Application No: 02DRB-00924 (SBP) Project #1001973  
Project Name: RICHFIELD PARK SUBDIVISION Fee: \$  
Agent: Advanced Engineering Phone No.# 899-5570  
Your request for (SDP for SUB), (SDP for BP), (PREL/FINAL PLATS), (MASTER DEVELOP. PLAN), was approved on 4/26/02 by the DRB with delegation of signature(s) to the following departments.

June 26, 2002

**7. Project #1001973  
Application # 02DRB-00924  
Richfield Park Subdivision- Helmick Homes**

DUMPSTER ENCLOSURE DETAIL  
NTS

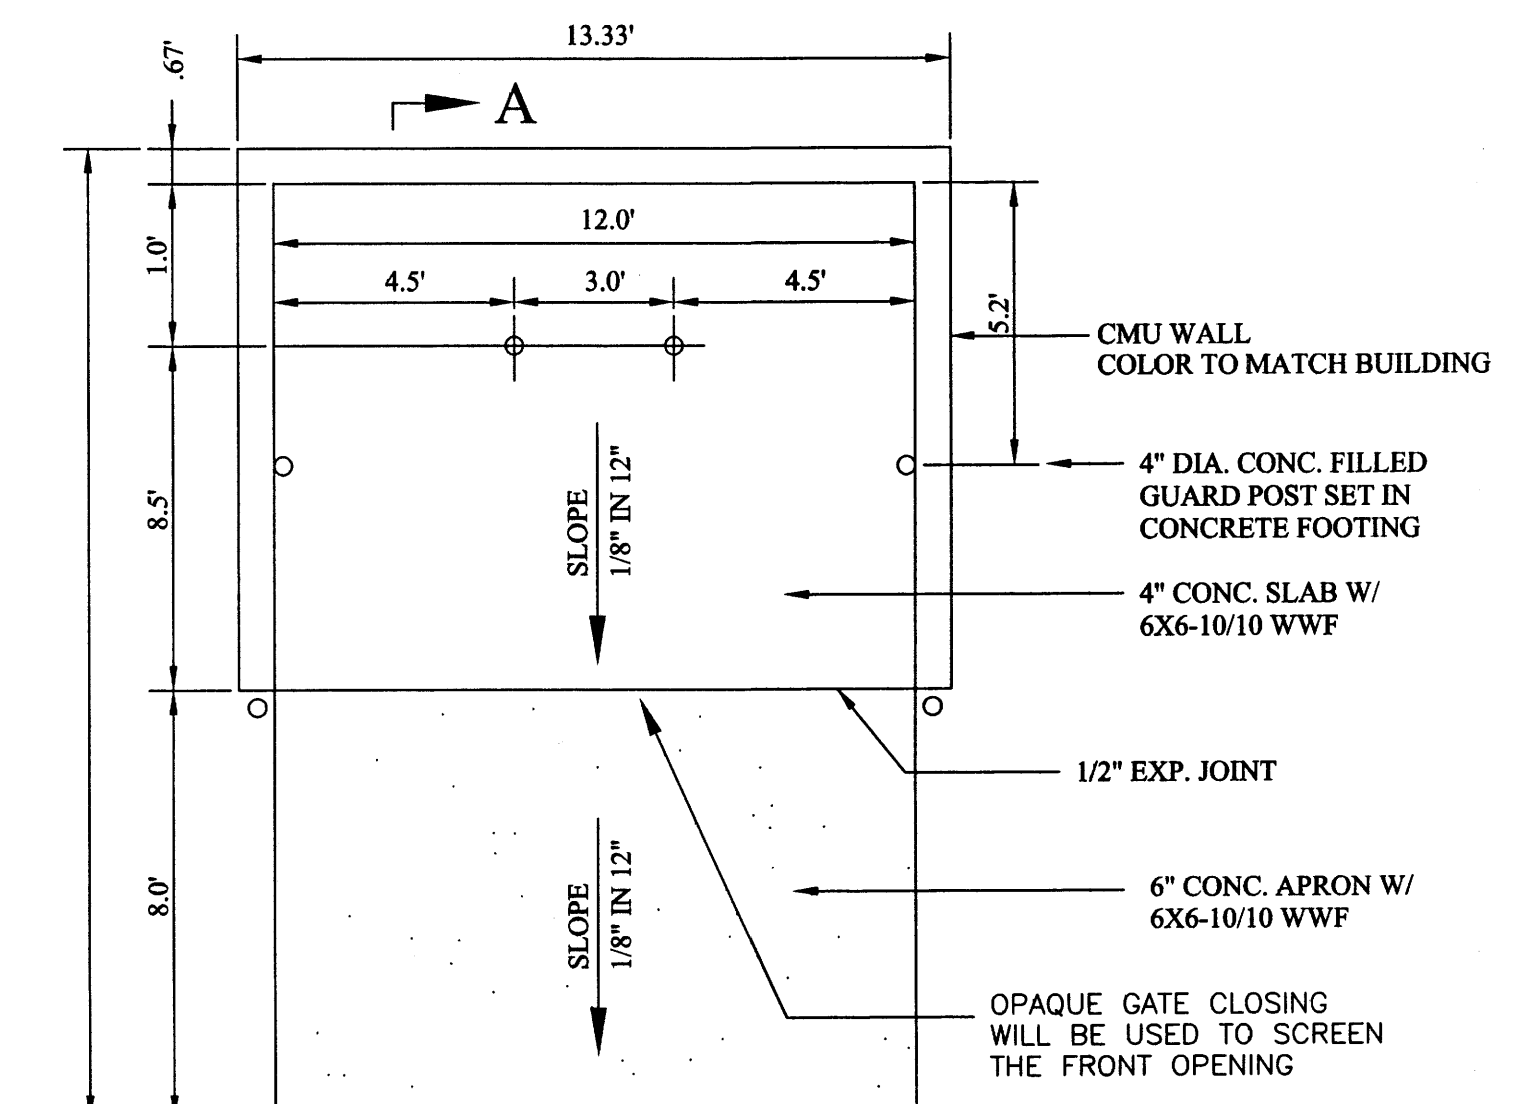
1. Re: the dumpster detail: Add the color of the CMU wall and the type of opaque gates proposed.
2. See Sheet 2 of 4 – Landscaping Plan.
  - a. Delete the language “Final landscaping layout and design to be determined upon receipt of final grading plan”.
  - b. The number of plants and type of plants indicated on the Plant Legend do not appear on the design. Also, why are half of the beds along Adams Street NE and Columbine Street landscaped only with gravel?
3. Please provide color samples of the stucco.
4. The spelling of “piched” under General Note #6, Sheet 1 of 4 needs to be corrected. The correct spelling is “pitched”.
5. A detail of the proposed parking lot and building mounted lighting needs to be added. Also, add a note that no fugitive light is allowed to escape the site.
